# CITY OF ALBUQUERQUE

**RE: Valle Prado Unit 3  
Drainage Report and Grading and Drainage Plans  
Engineer's Stamp Date 3-26-2015 (File: C09D011A)**

Re: Valle Prado Unit 3, Grading and Drainage Plan (C09/D011A)

CITY OF ALBUQUERQUE PUBLIC WORKS DEPARTMENT	
VALLE PRADO UNIT 3 GRADING AND DRAINAGE PLAN	
Design Review Committee	City Engineer Approval
City Project No. XXXXXX	Zone Map No. C-09-Z
Sheet 1	Of 2

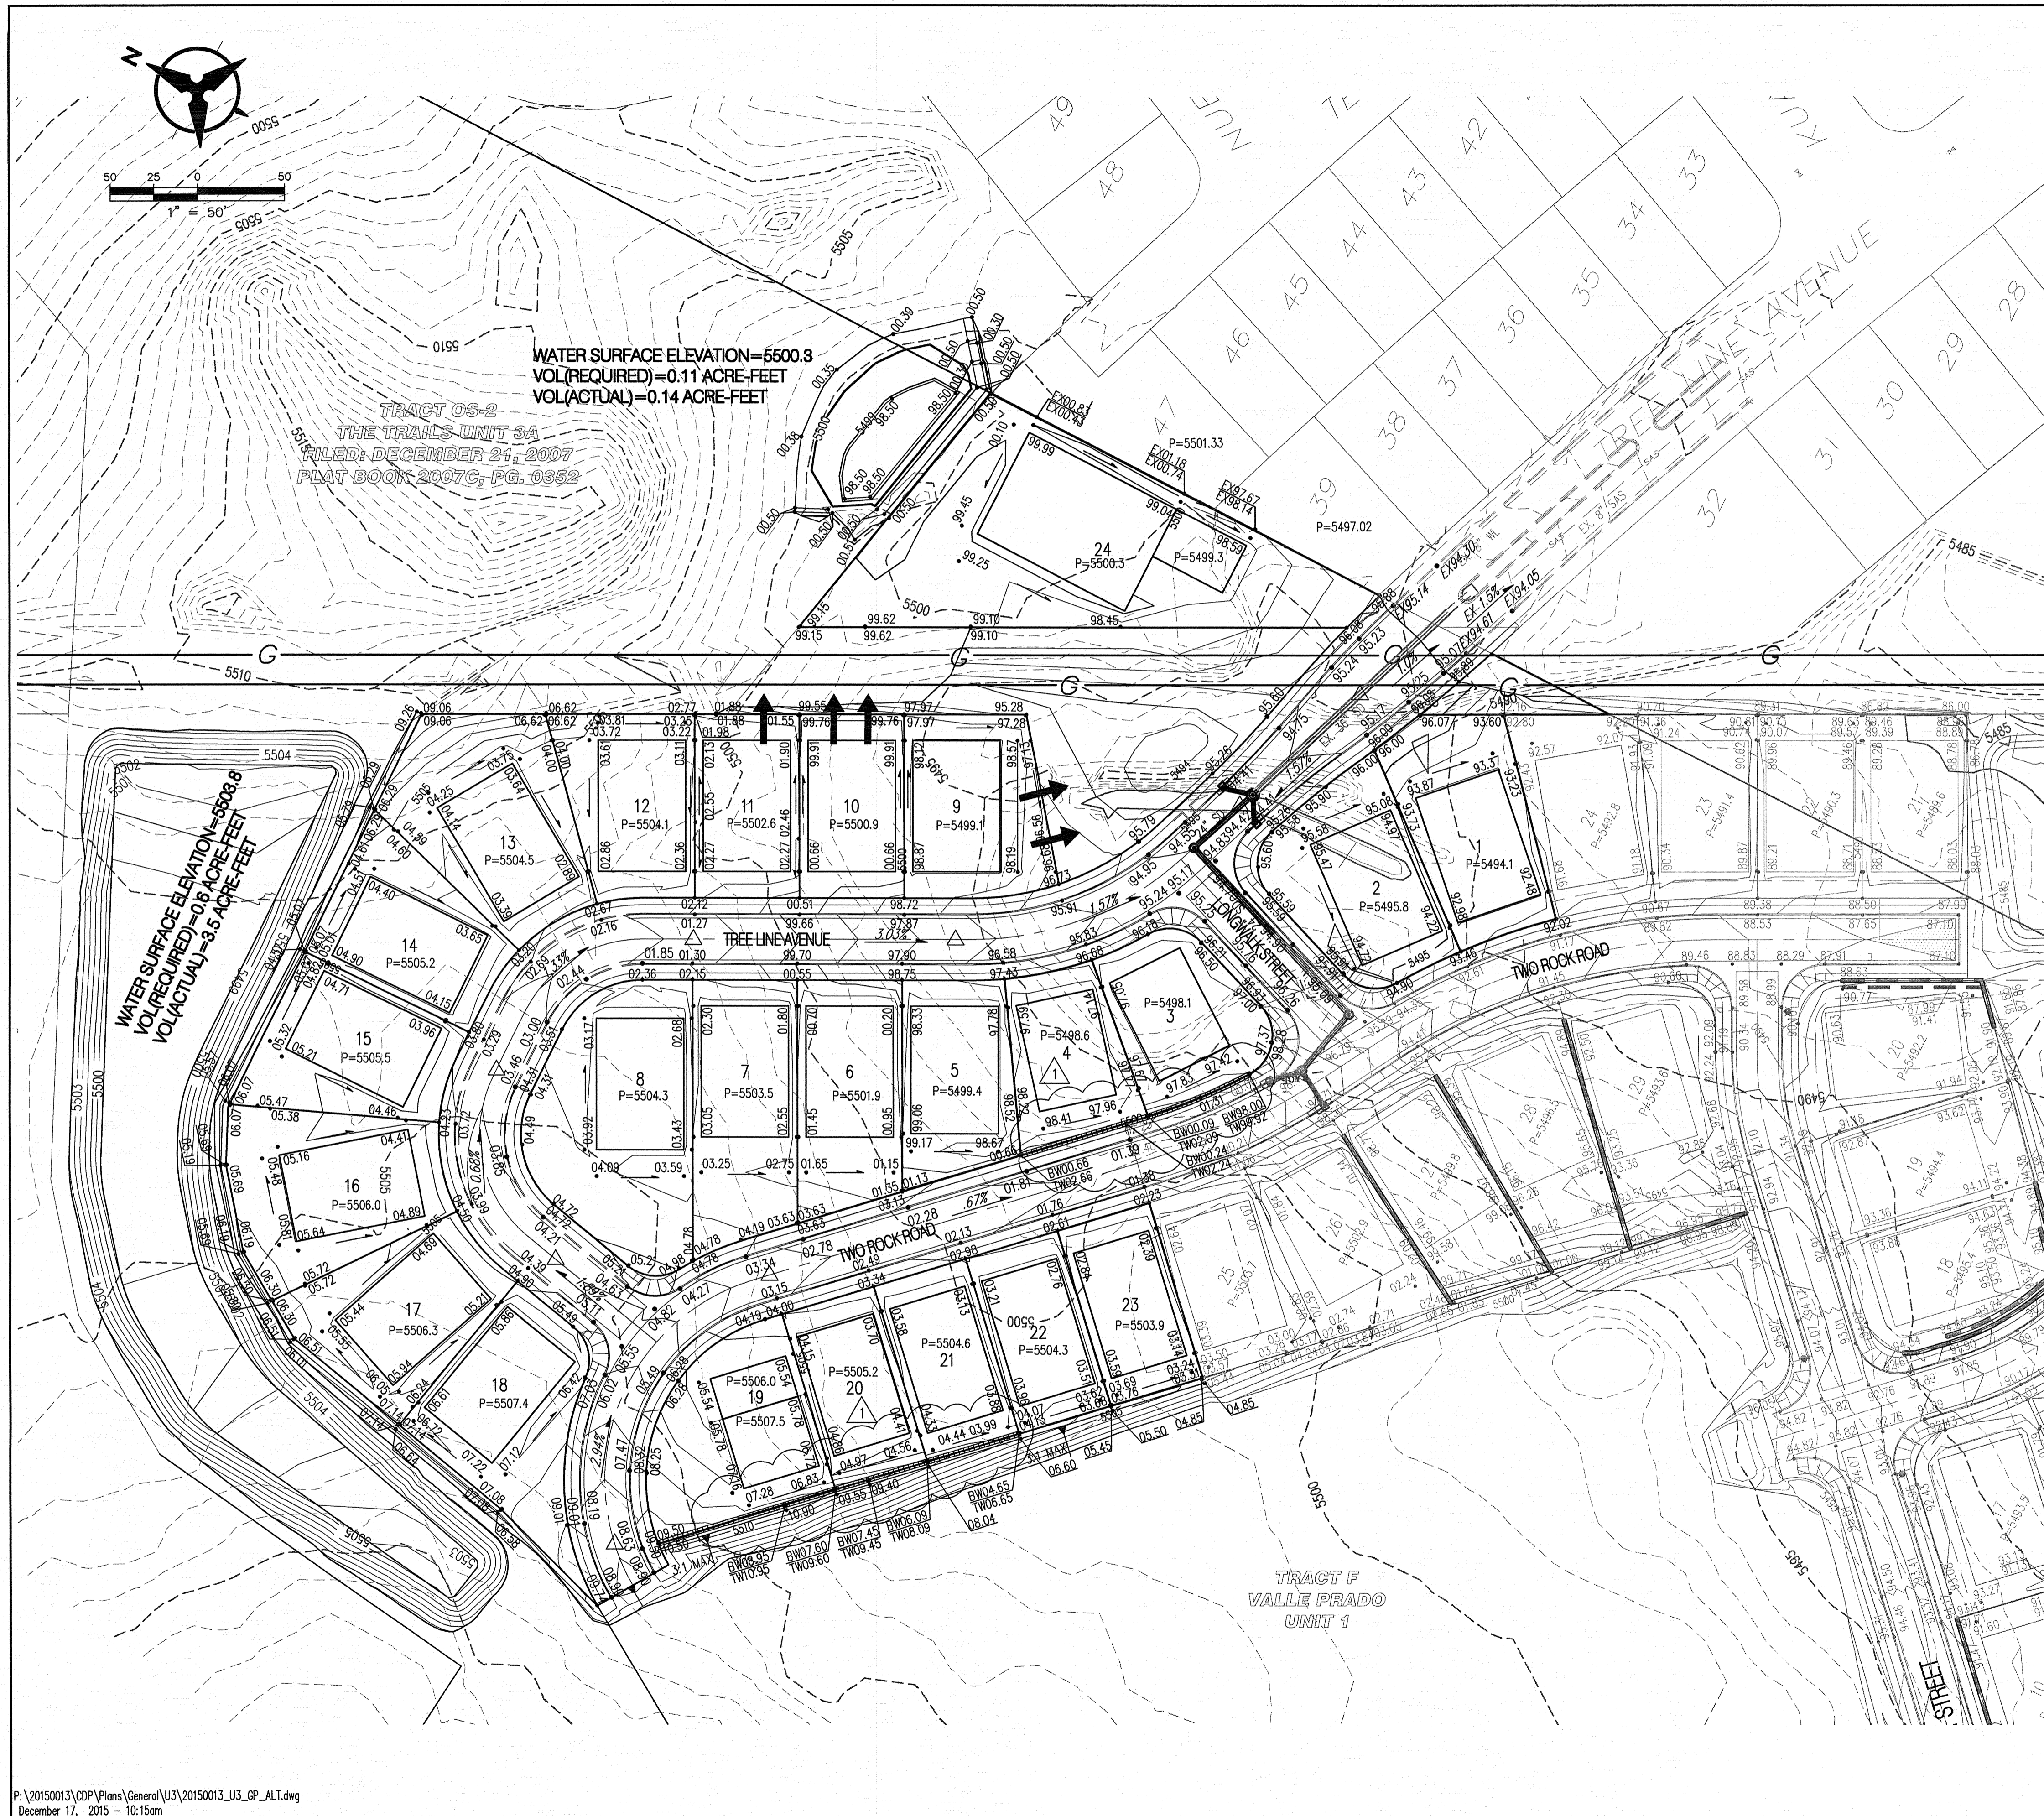
- 2. Tract OS-2 seems to have historically drained thru Lot 24. Wall on North side of lot needs to allow historic flows to pass. The G&D Plan shows that runoff is directed towards the east side of the lot, which may impact adjacent Lots 39 and 47. What are the pad elevations of these lots? Show grades beyond property line. Is there a wall? It would be preferable for offsite flows to drain to gas easement side. **A small retention pond has been added on Tract OS-2 to capture the historic flows that impact Lot 24. The grading plan matches the existing wall grades on the west side (Valle Prado side) of the wall along Santa Fe at the Trails Lots 39 and 47. As-built elevations from the grading and drainage certification for Lots 39 and 47 have been added to the grading plan.***

3. *Most of Lots 9, 10 and 11 drain to gas easement as opposed to Tract A or Tree Line Avenue. Most of Lots 10 and 11 drain to the gas easement. Lot 9 grading has been revised to drain to Tract A area outside the gas easement.*

5. *Can a retaining wall be avoided on Lots 3 & 4? The rear yard retaining wall on Lots 3 & 4 is necessary due to the existing ground elevation differential between Two Rock Road and Tree Line Avenue and the location of basalt in Two Rock Road behind Lots 3 and 4. In addition, Tree Line Avenue needs to be lower than Two Rock Road at Longwalk Street to direct runoff to the sump in Tree Line Avenue. See additional grades provided on revised grading plan.*

6. *Why is the grade raised to 5510' South of Lots 19, 20 and 21? How does this fit in with the future plans for the extension of Two Rock Road to the future Sandmark Road and the Future Basin 3 (from Unit 1&2 Drainage Report)? The 5510' elevation is based on the conceptual grading plan for future lots that will back to Lots 19-21. The conceptual grading plan is based on depth to basalt for the future extension of Sandmark and Two Rock Roads and the lots that front Sandmark Road.*

8. *What is the datum difference in order to compare earlier and adjacent work orders?* **Approximately 2.7 feet.**
9. *Show existing flowline elevations and slopes where Tree Line ties into the existing at Santa Fe at the Trails.* **The existing information has been added.**

UNIT 3 BASIN MAP

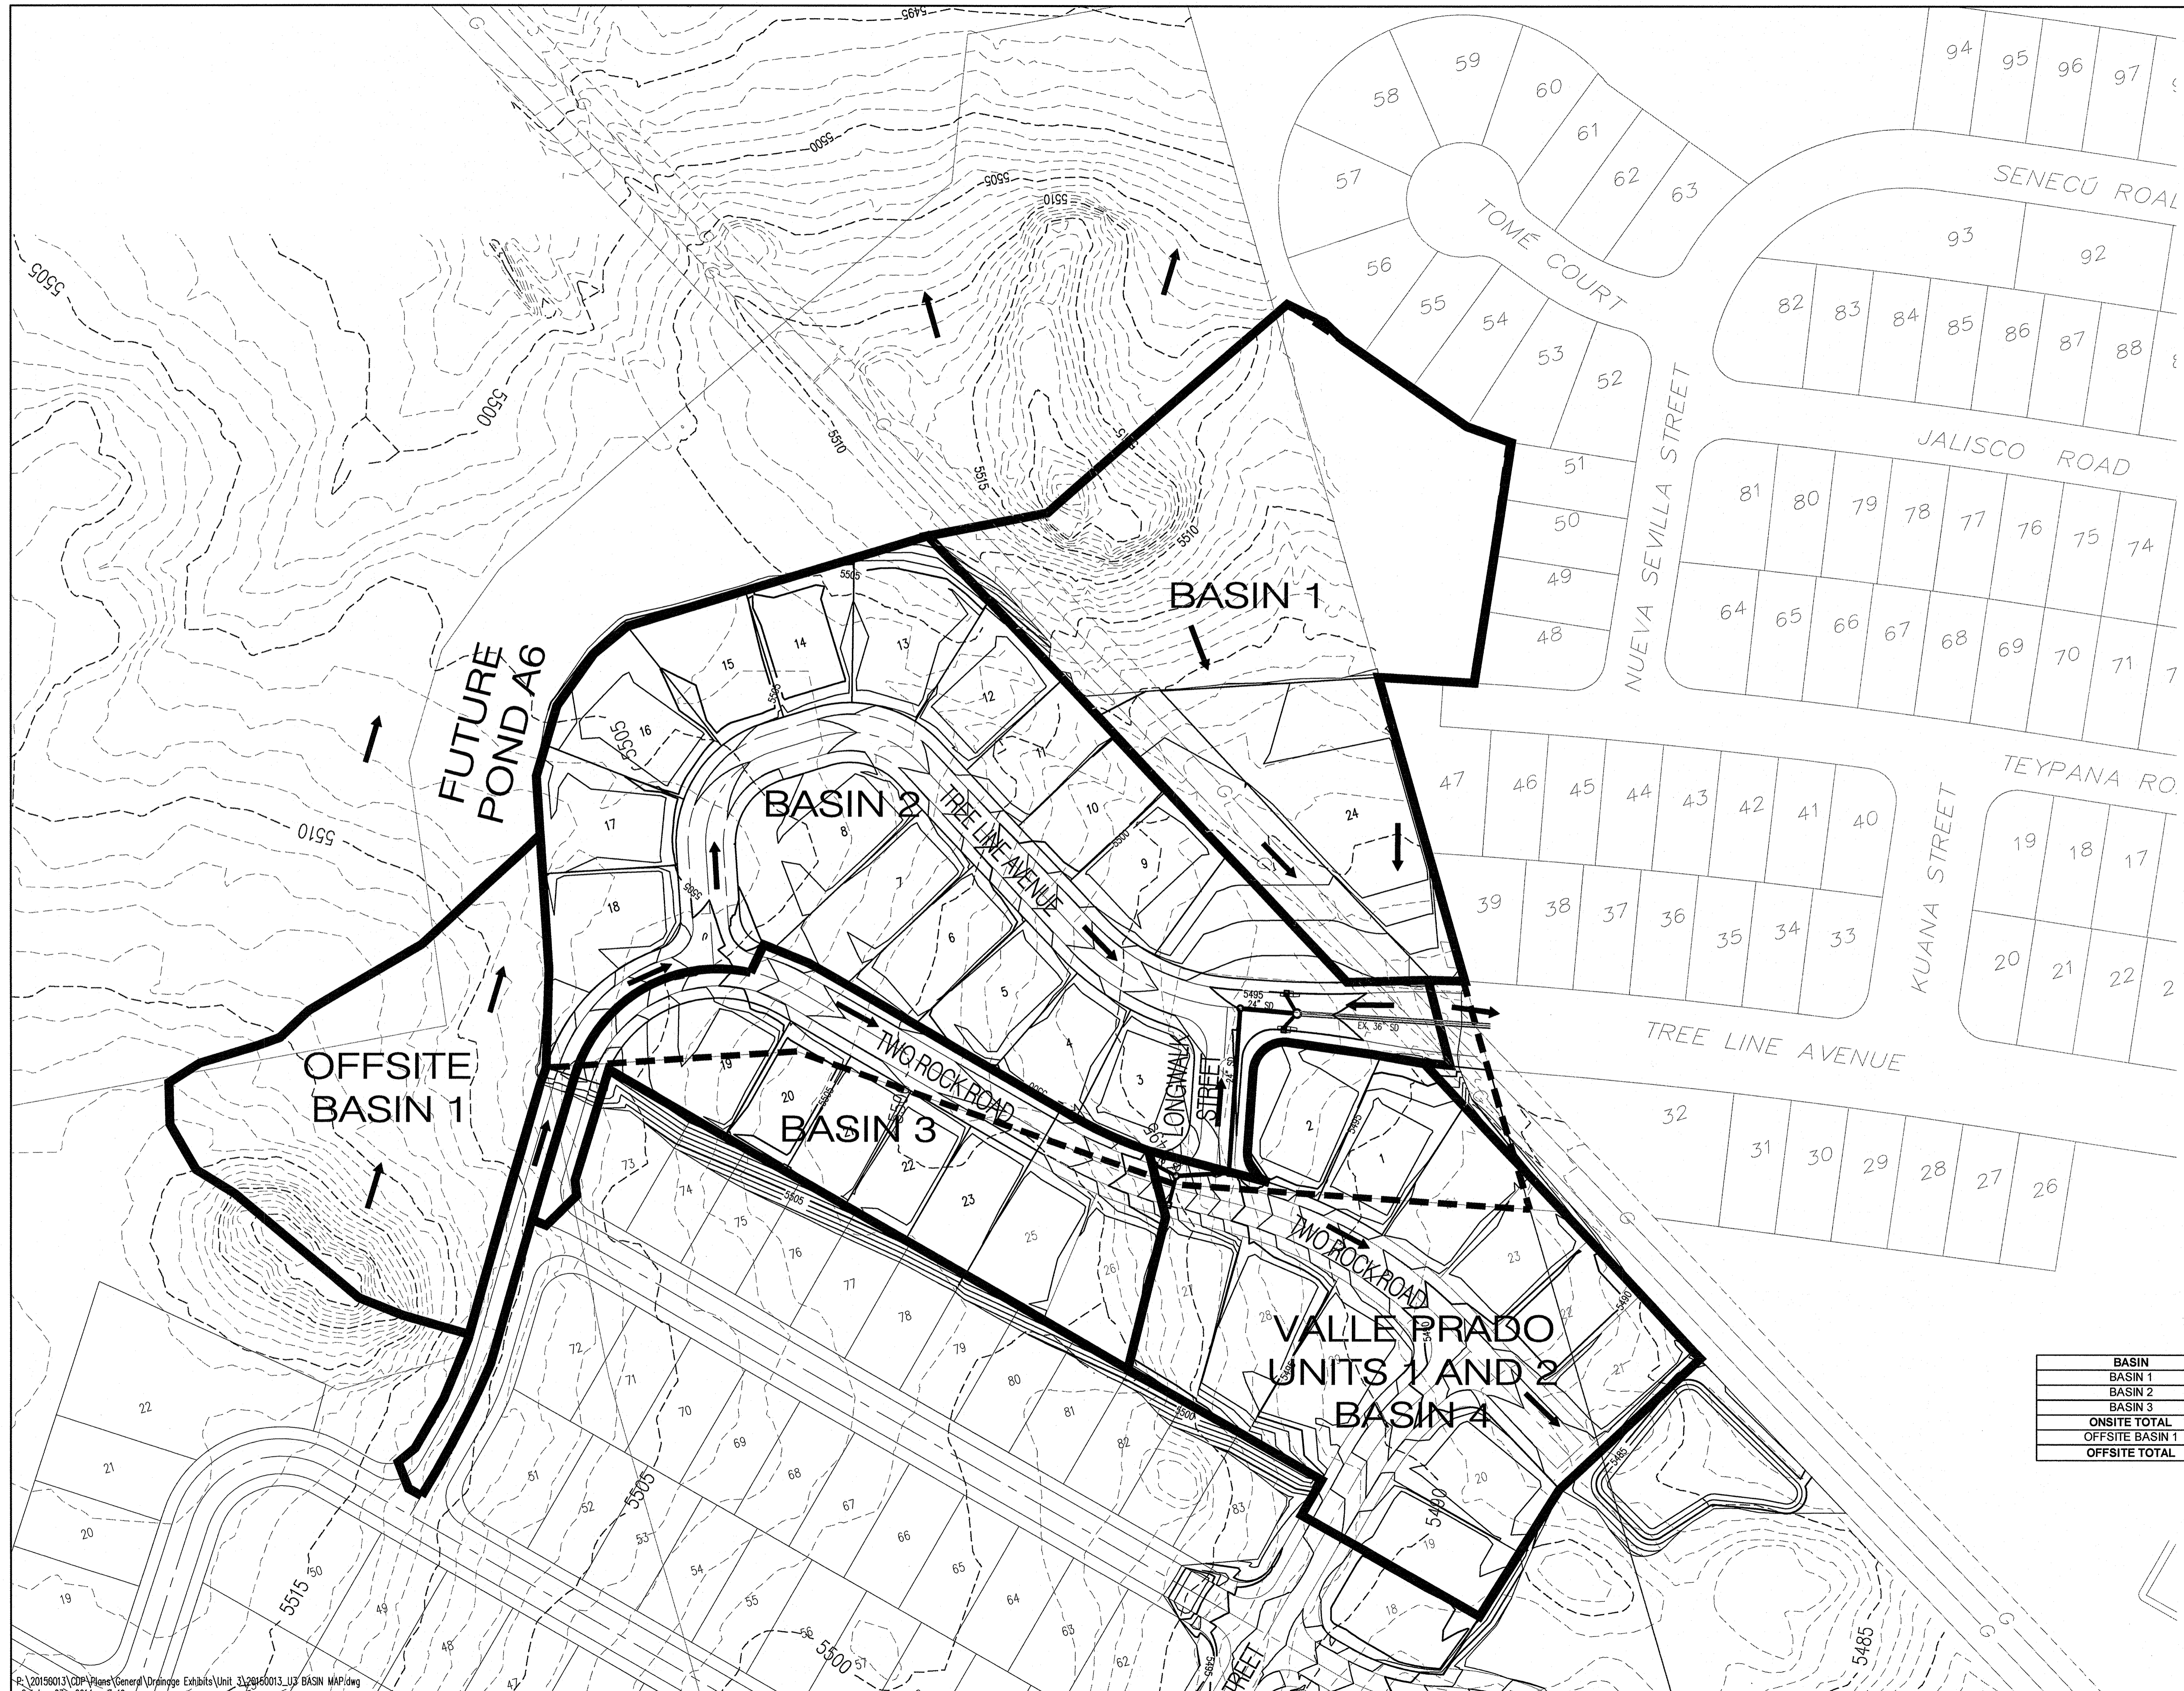
7. *Drainage Report (IV) states Unit 3 is 14.5 acres, but Basin Map shows 9.1 acres. The 14.5 acres is based on the existing Tracts to be subdivided per the Preliminary Plat. Tract C, 7.7 acres, will be subdivided as part of future phases of the Valle Prado development. Basin 1 includes about 2 acres from Tract OS-2 that is not part of the 14.5 acres that is being subdivided to create Valle Prado Unit 3.*
